**KIRKLEES METROPOLITAN COUNCIL  
INVESTMENT & REGENERATION SERVICE**

**DELEGATED DECISION TO DETERMINE PLANNING APPLICATIONS**

Reference No:	<b>2025/62/90149/E</b>
Site Address:	1, Low Fold Court, Denby Lane, Upper Denby, Huddersfield, HD8 8TZ
Description:	Erection of outbuilding (within a Conservation Area)
Recommending Officer:	Faiza Bano

## **OFFICER REPORT**

Drawing Title: EXISTING AND PROPOSED SITE LAYOUTS, ELEVATIONS & FLOOR PLAN

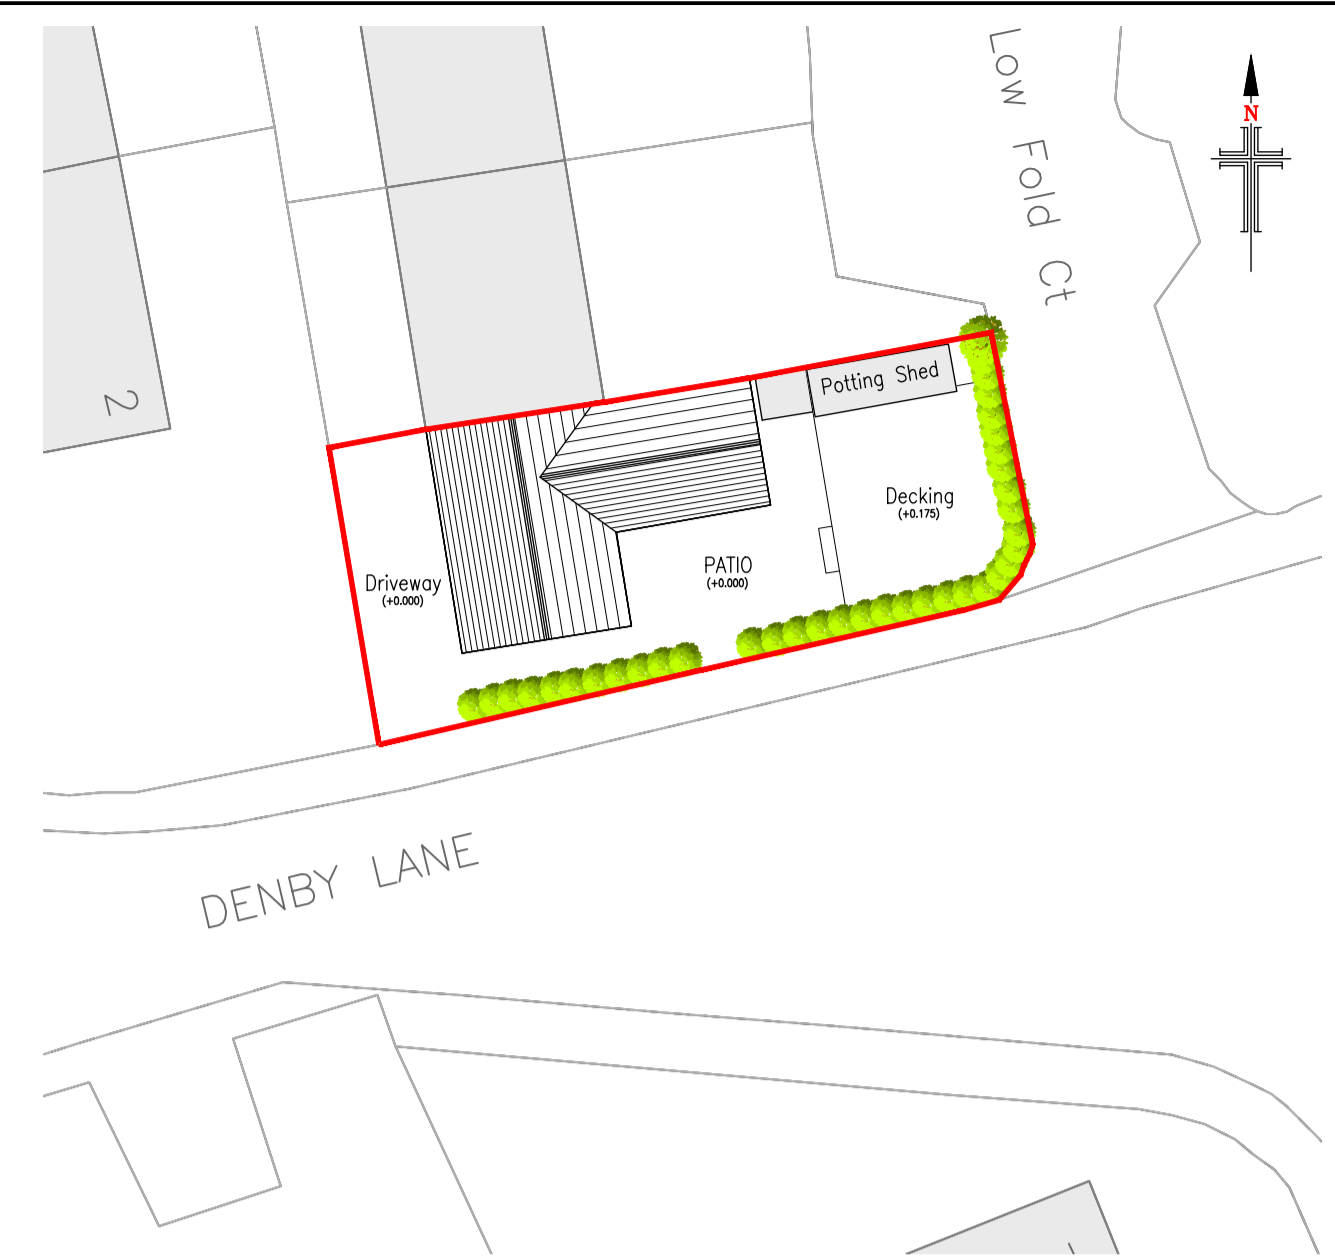
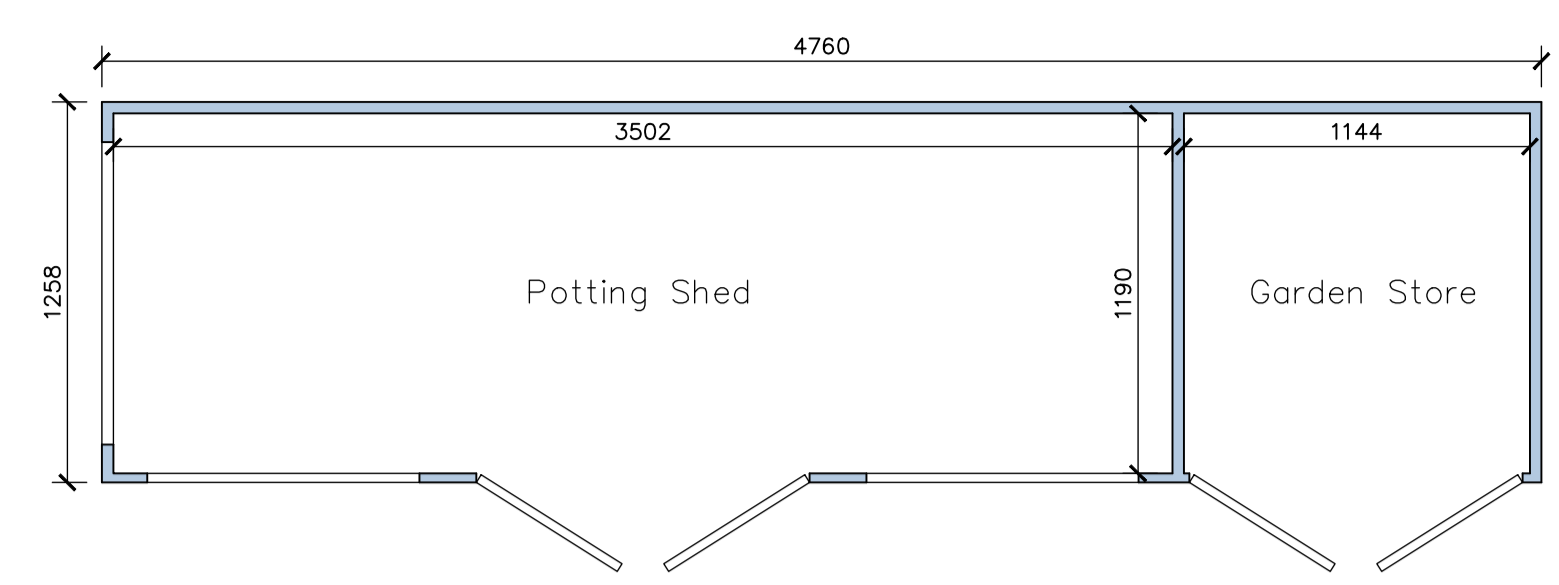
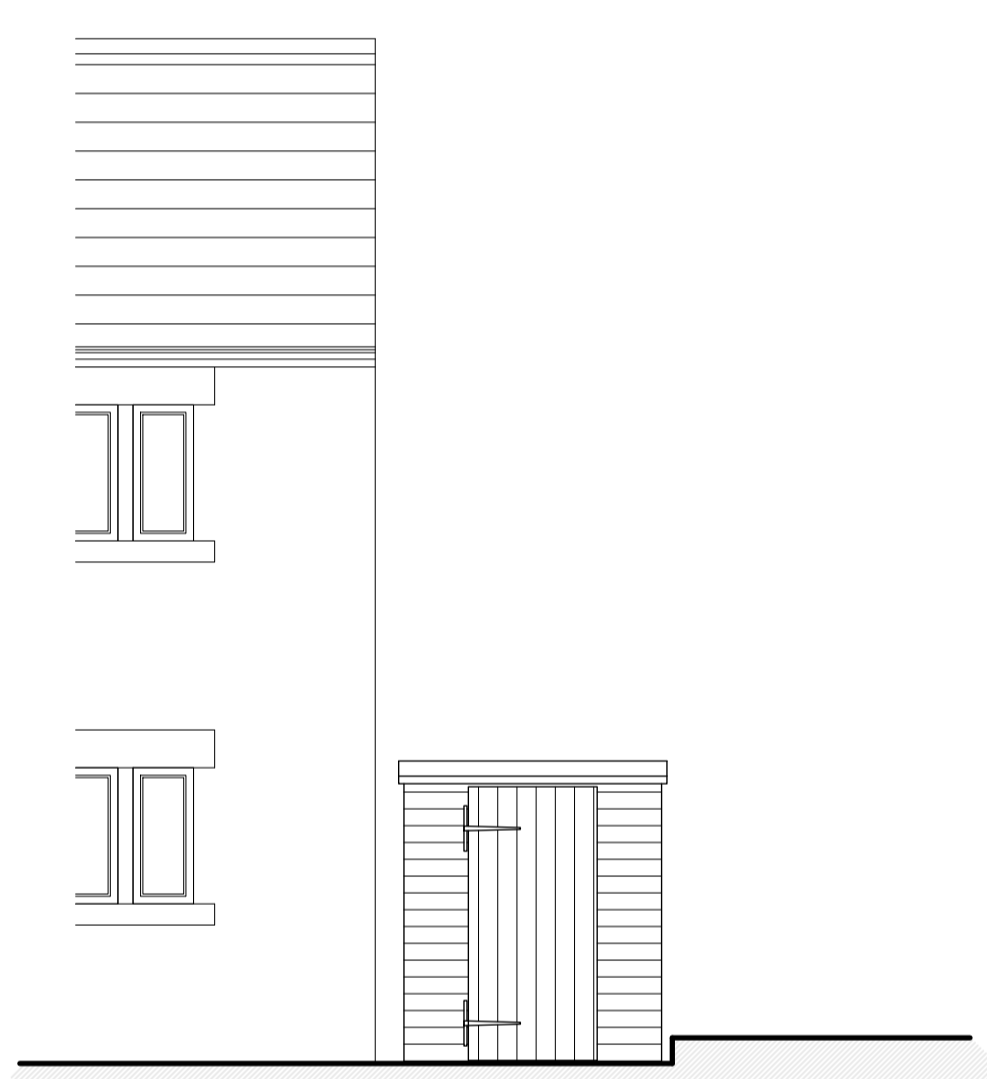
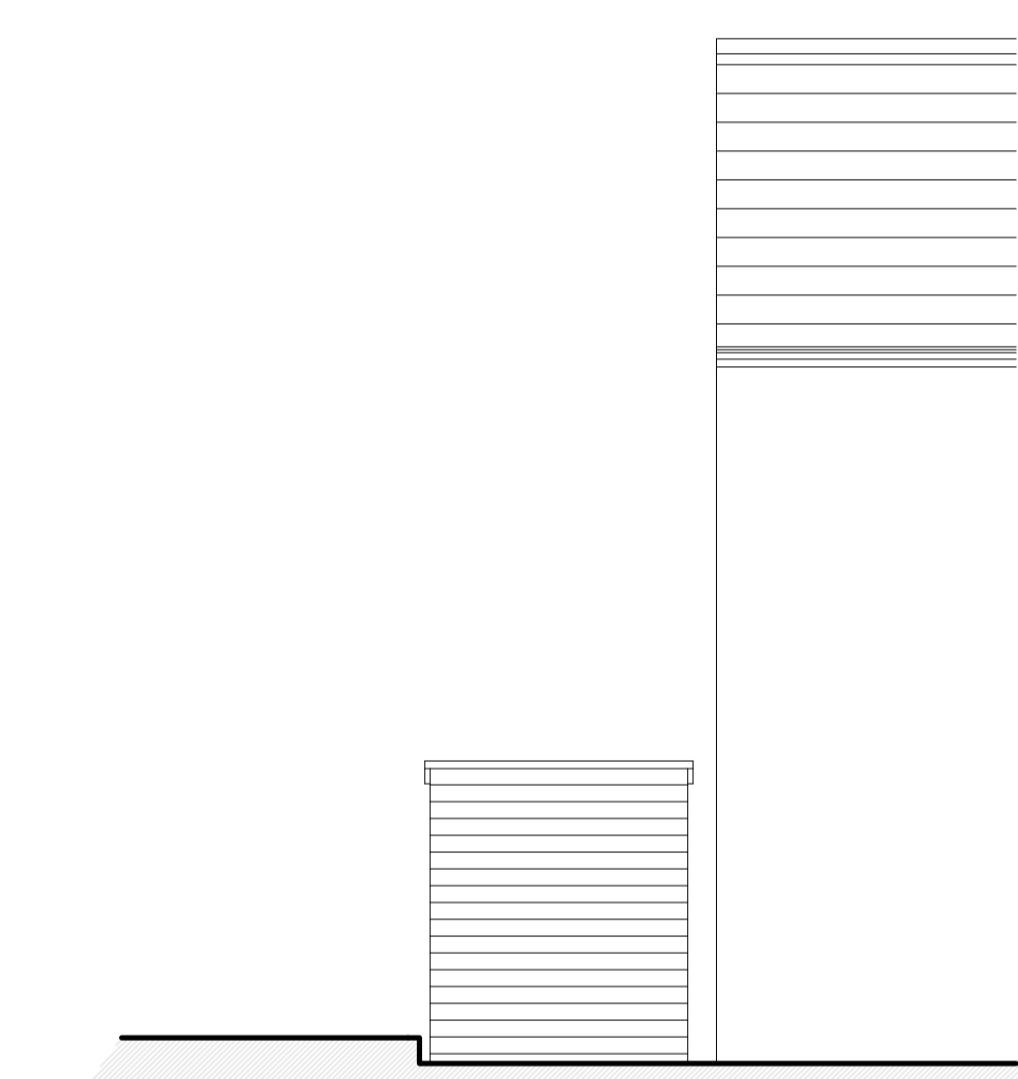
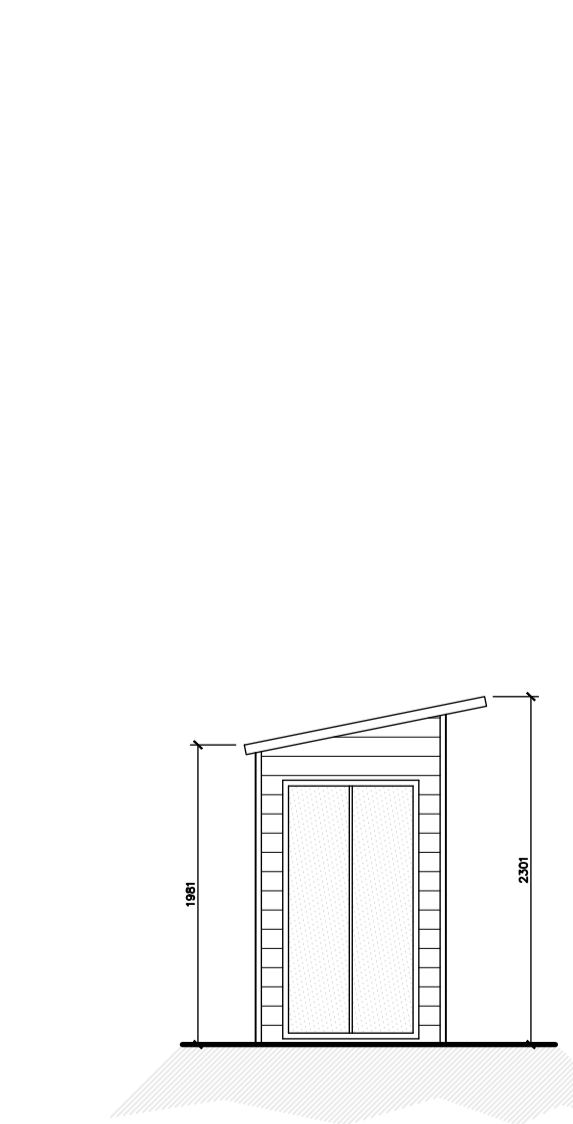
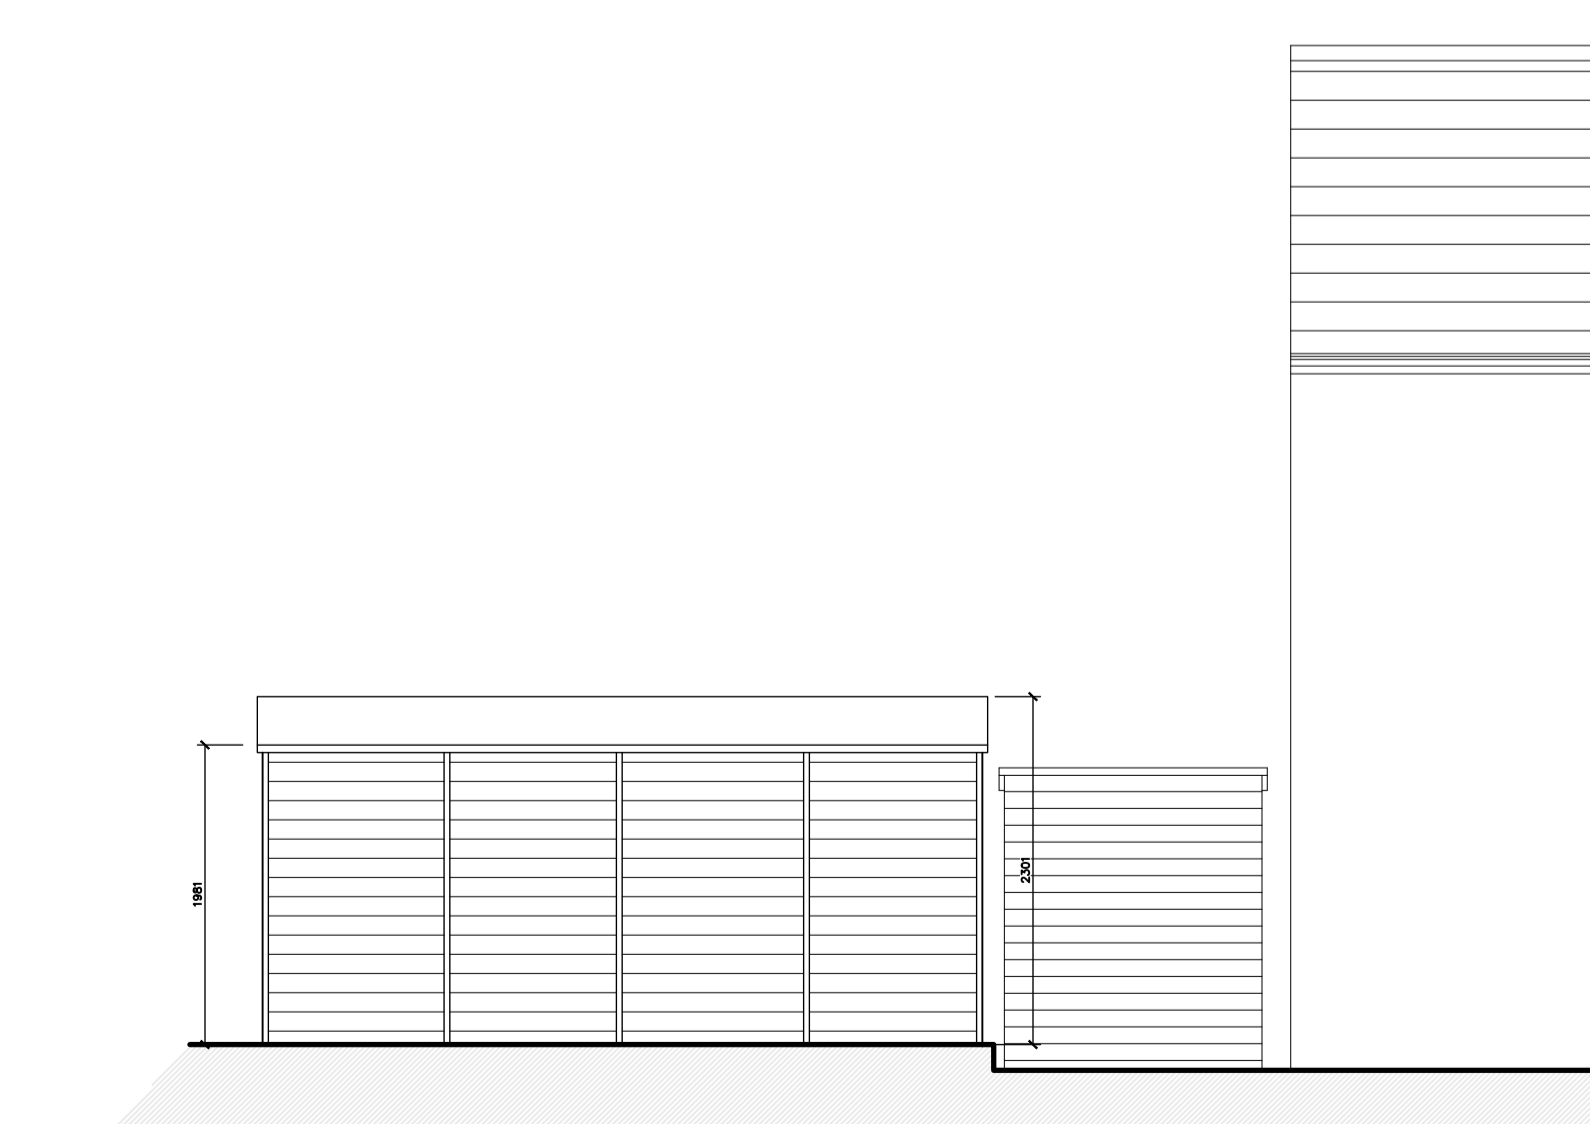
The proposed outbuilding would feature a lean-to roof, with a depth of 1.3m, a width of 4.8m and an overall height of 2.3m.

The proposed garden shed would be constructed from shiplap timber and the roof will be finished with felt.

**KC Conservation & Design (informal)** – In this case, the proposed shed is quite minor, and sited as sympathetically as possible on this site. The site is surrounded by an appropriate stone boundary wall and hedges that will screen the proposed sheds. The proposed timber materials are adequate in this case and will weather over time. You may wish to consider a condition to state the sheds shall be stained brown or stained/painted a dark colour and maintained as that for future.

Due to the screened boundary, the proposal will not be visible from the street scene and is located within the rear amenity area of the dwelling. The proposed outbuilding is single-storey and does not exceed the eaves height of the original house minimising any impact.

Following advice by KC Conservation and Design, and in order to maintain a development that sits comfortably within its setting, a condition is recommended for the outbuilding to be stained brown or stained/painted a dark colour and maintained as such in the future.

**Overshadowing/Loss of Light/Overbearing:** The proposal is located along the shared boundary, it has an overall height of 2.3m, and the distance between location of the outbuilding and nearest habitable room, along with its orientation, ensures that sun paths are not obstructed. Or would there be a detrimental impact on the amenity space of the occupants. Therefore, no significant issues related to overshadowing, loss of light, or overbearing impact are anticipated.

2. Notwithstanding the submitted detail, within three months of being erected the outbuilding hereby approved shall be stained dark brown or similar and thereafter maintained.
